**MBNA** AMERICA<sup>SM</sup>  
HALLMARK CENTER SITE HARDENING

OVERALL PLAN

C1.0

OVERALL PLAN

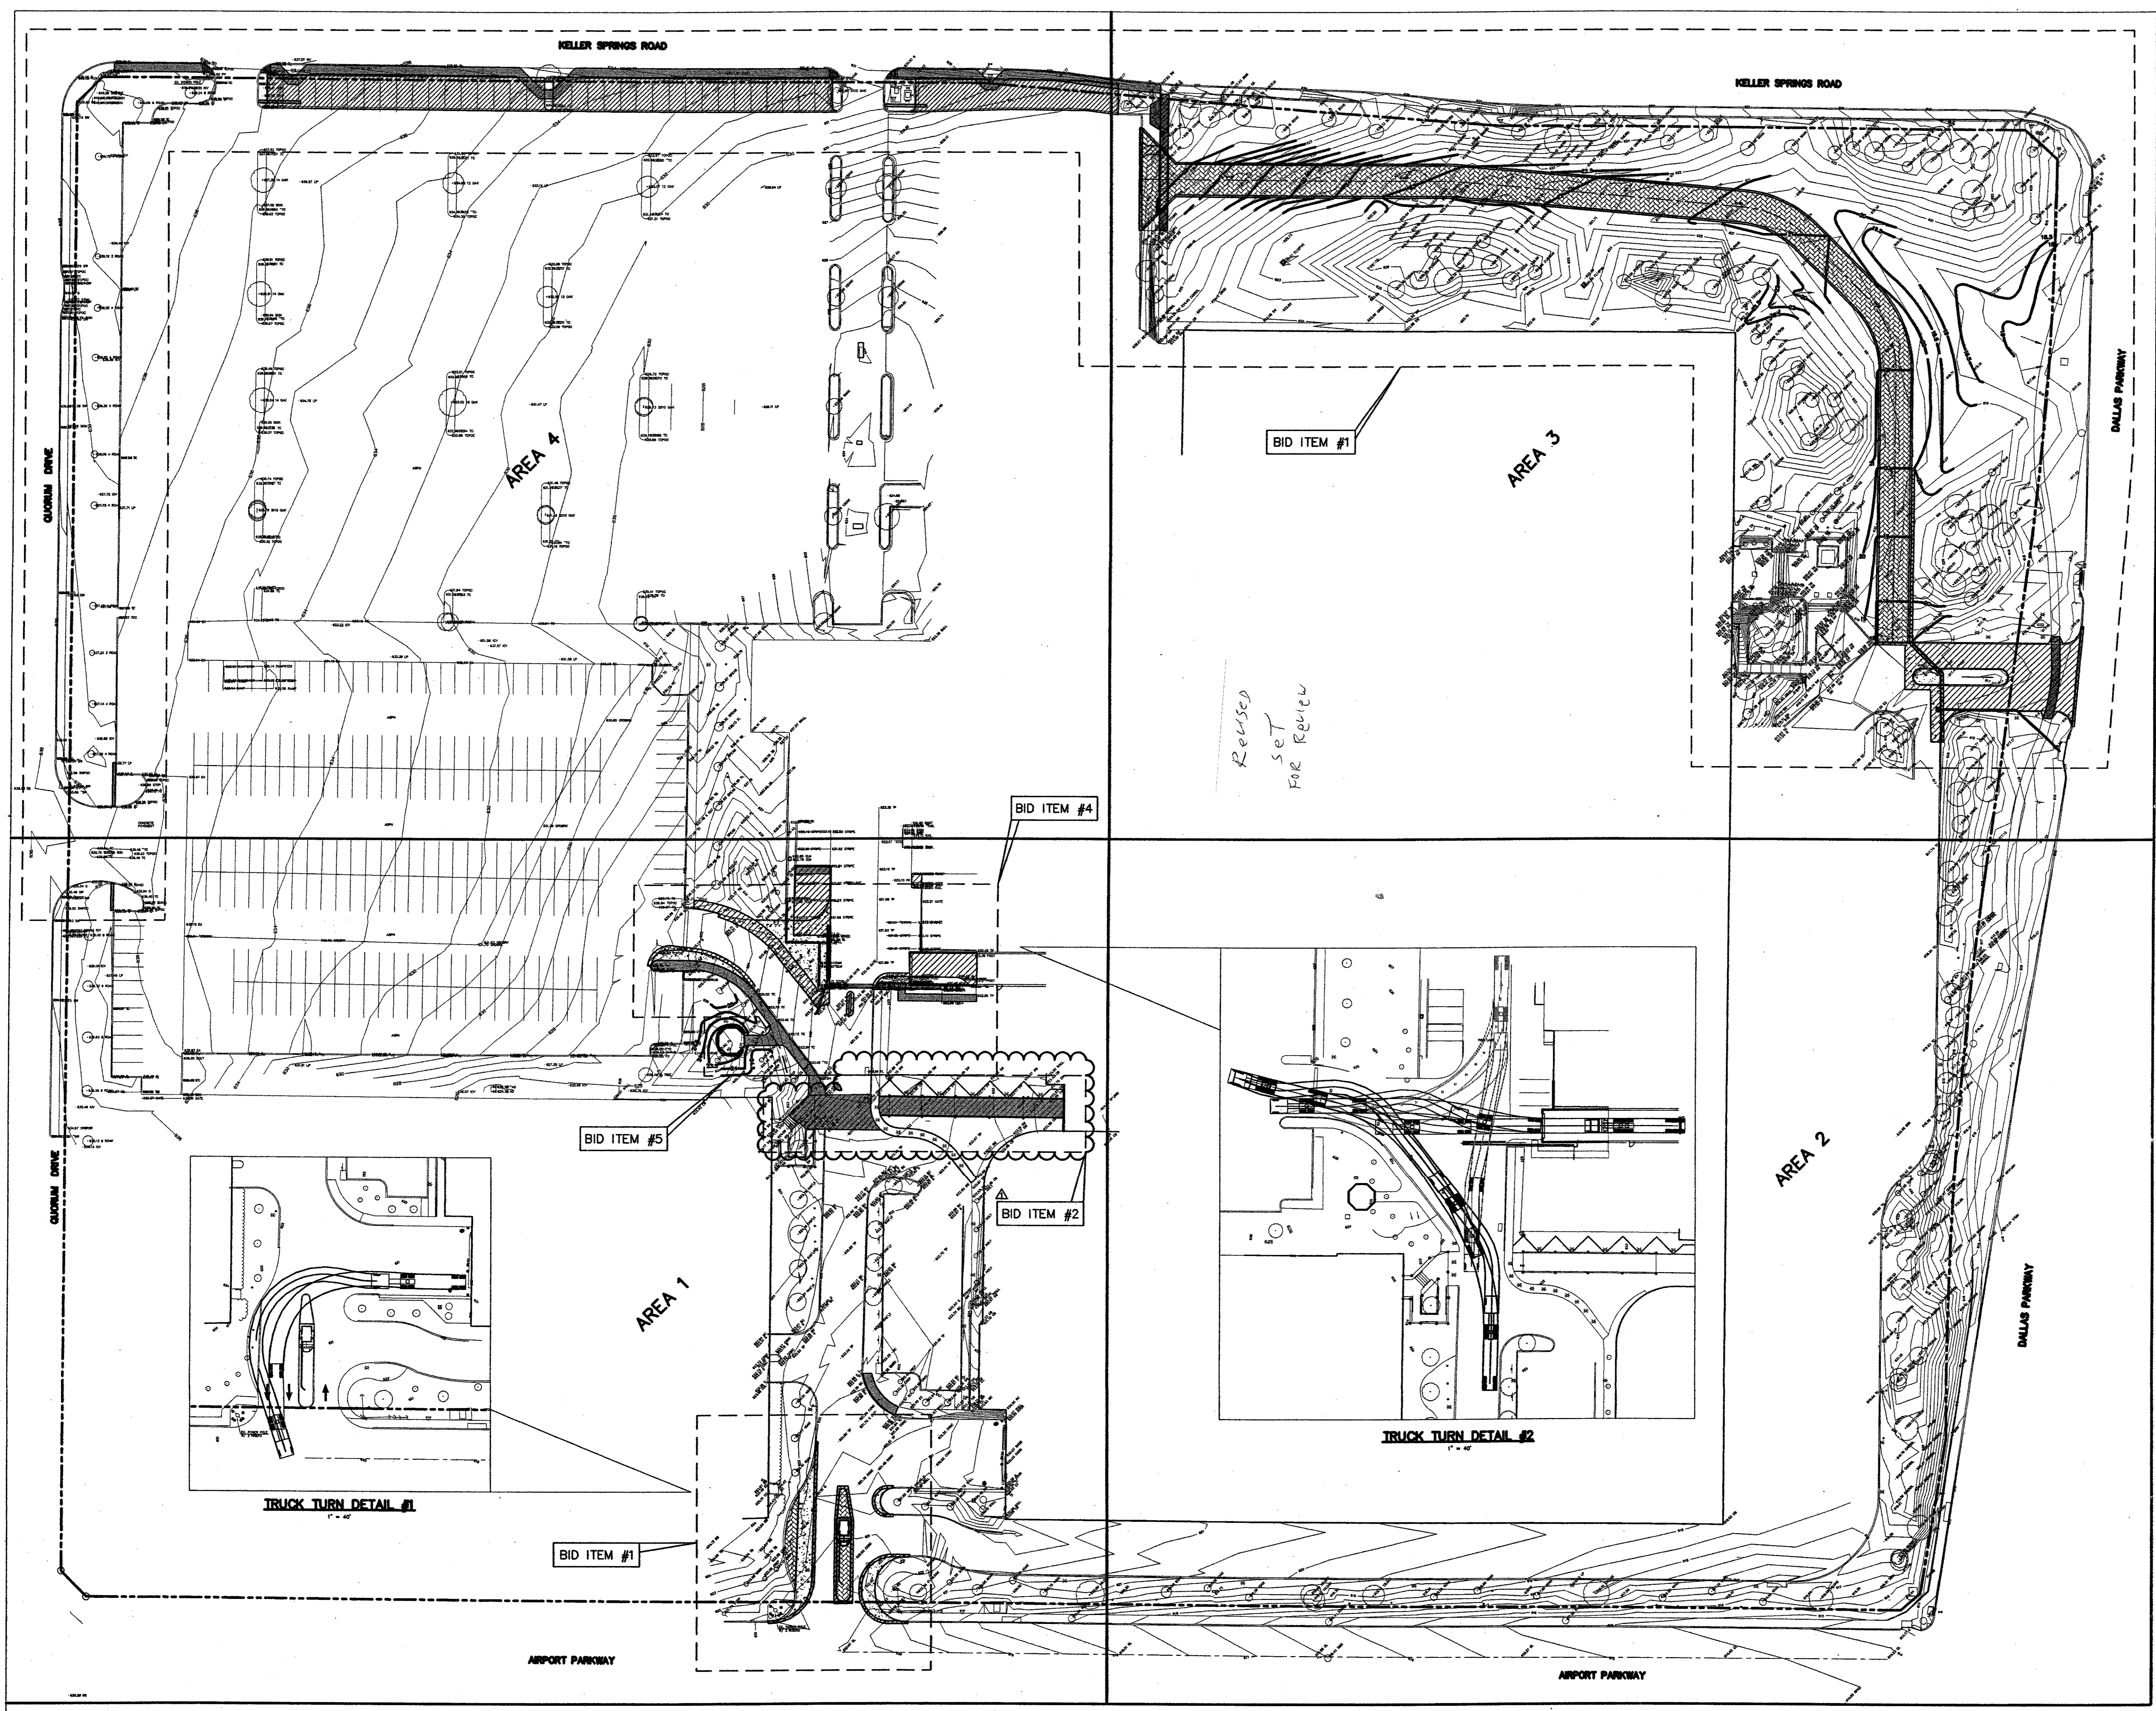
1) Obtain ROW Excavation Permit from:  
Town of Addison  
Public Works Dept.  
16801 Westgrove Rd.  
Addison, 75001

2) Note changes to Sidewalk + curb Specs. Also:  
SEE ATTACHED

3) Curb expansion "bars" are to be placed at all locations where new curb abuts existing.
